This is to certify that CAIRNS ROSEMARY KENNEDY /Joel Yeak
has permission to adding height ~~Add height to existing~~ Amendment to ~~to create~~ Permit # ~~Brd floor before putting on roof~~ 051033

Permit No: 05-1732
 Issue Date: JAN - 6 2005
 CBL: 43 E017001

RE: Rosemary Cairns 3 story addition

I analyzed the 3 story addition from the plans you sent to me for the Cairns single family residential project in Portland. The addition is 18 feet wide by 28 feet long with a connector to the main house. The walls are 6 1/4" Logix ICF with a truss roof system and wood floor system. The walls have #4 bars vertical space 24" oc and #4 bars horizontal spaced 16" oc. The tables for design from the Logix engineering manual are limited to up to 2 stories. Therefore the project with 3 stories required further engineering analysis.

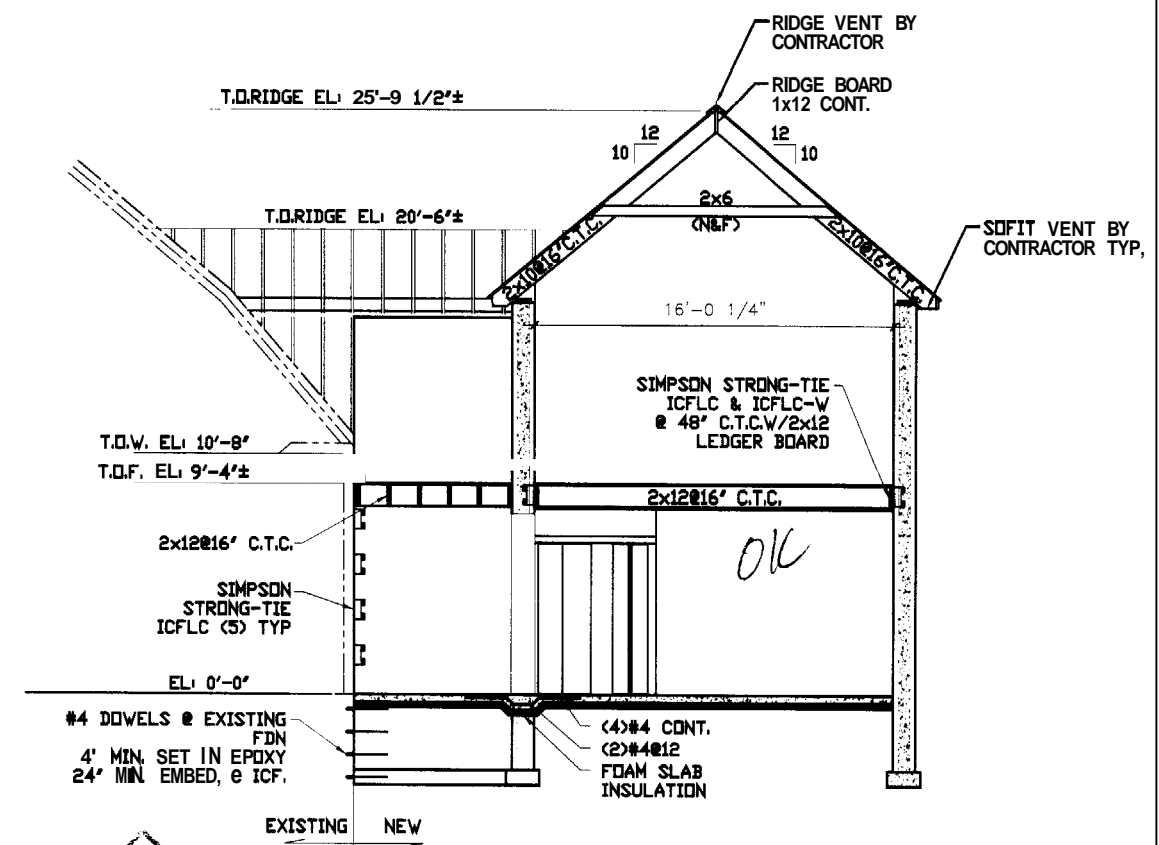
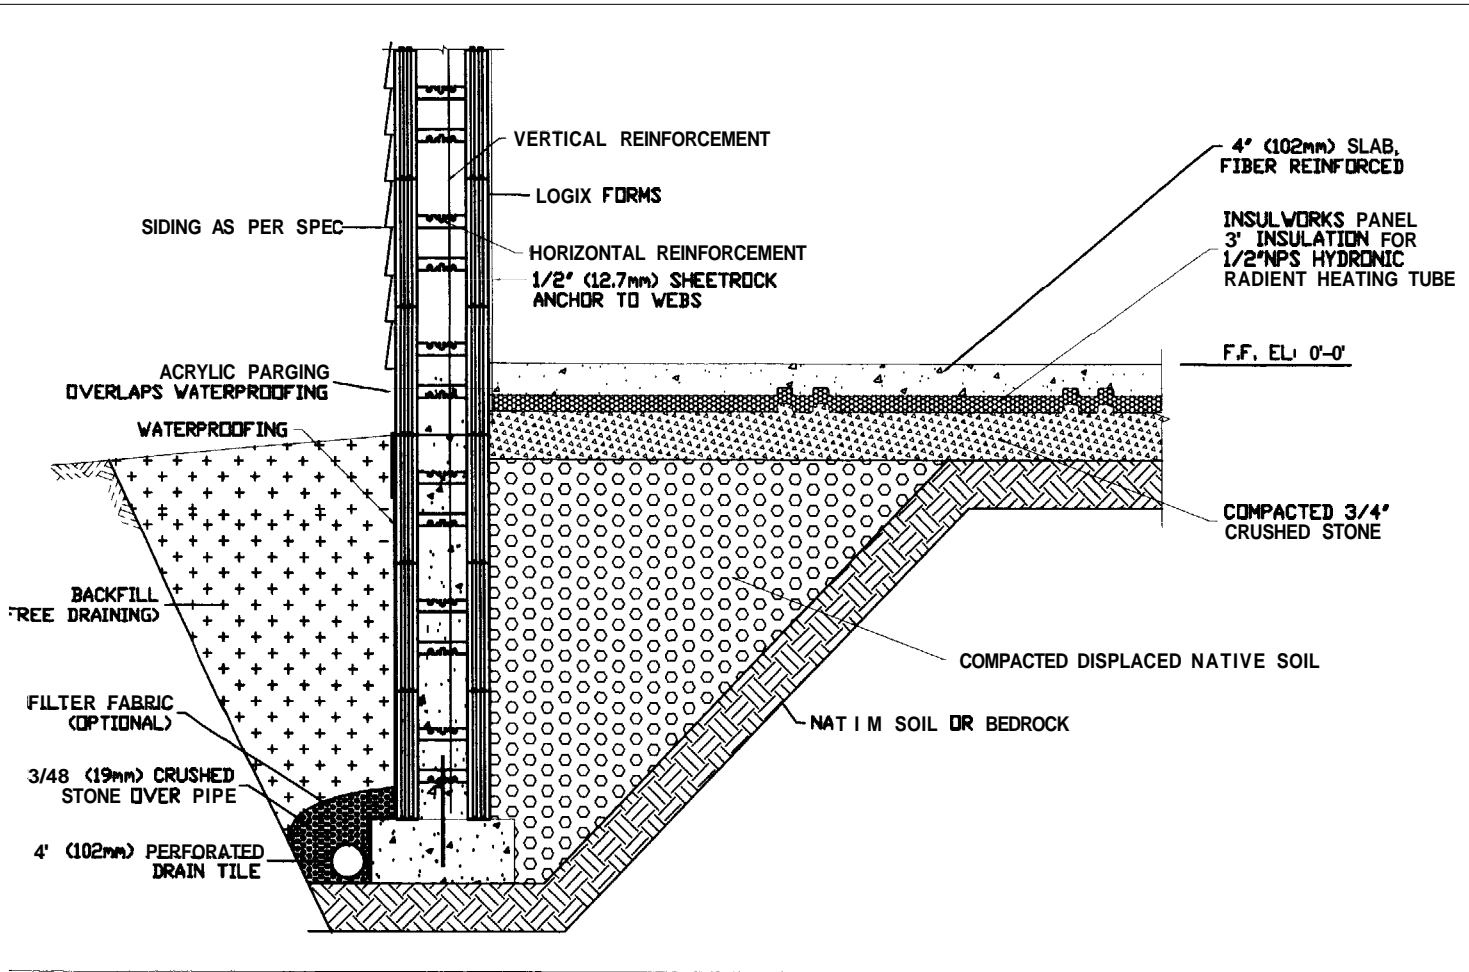
Comments:
 12/6/05-tmm: spoke w/Joel York - need to show design to structure can carry another story and need floor hanger detail.
 12/13/05-tmm: Mike N. spoke w/designer and went over the above items - they will resubmit engineering.
 12/22/05-tmm: rec'd additional engineering -ok to issue

I was asked to review the Logix engineering data with respect to the three story condition of the project. Table 2, Vertical Reinforcement for Above Grade Walls, of section 6.1 of the Logix engineering manual shows that #4 bars spaced 24" oc in a 6.25" wall are adequate for wind speeds up to 140 mph with a combined axial load of up to 4500 plf. The Cairns project has a design roof snow load of 55 psf, 3rd floor live load of 30 psf (sleeping), 2nd floor live load of 40 psf (living) and dead loads of 10 psf for all floors and roof. With the weight of the concrete the maximum axial load on the ICF wall is 2645 PLF well below the 4500 PLF limit of Table 2. Therefore the 6 1/4" ICF wall for this specific project is adequate for a 3 story residential structure as presented.

No other aspects of the project have been reviewed including the roof trusses, floor framing, slab on grade, attachment to the existing building or any other part of the project other than the ICF wall reinforcing with respect to a 3 story condition.
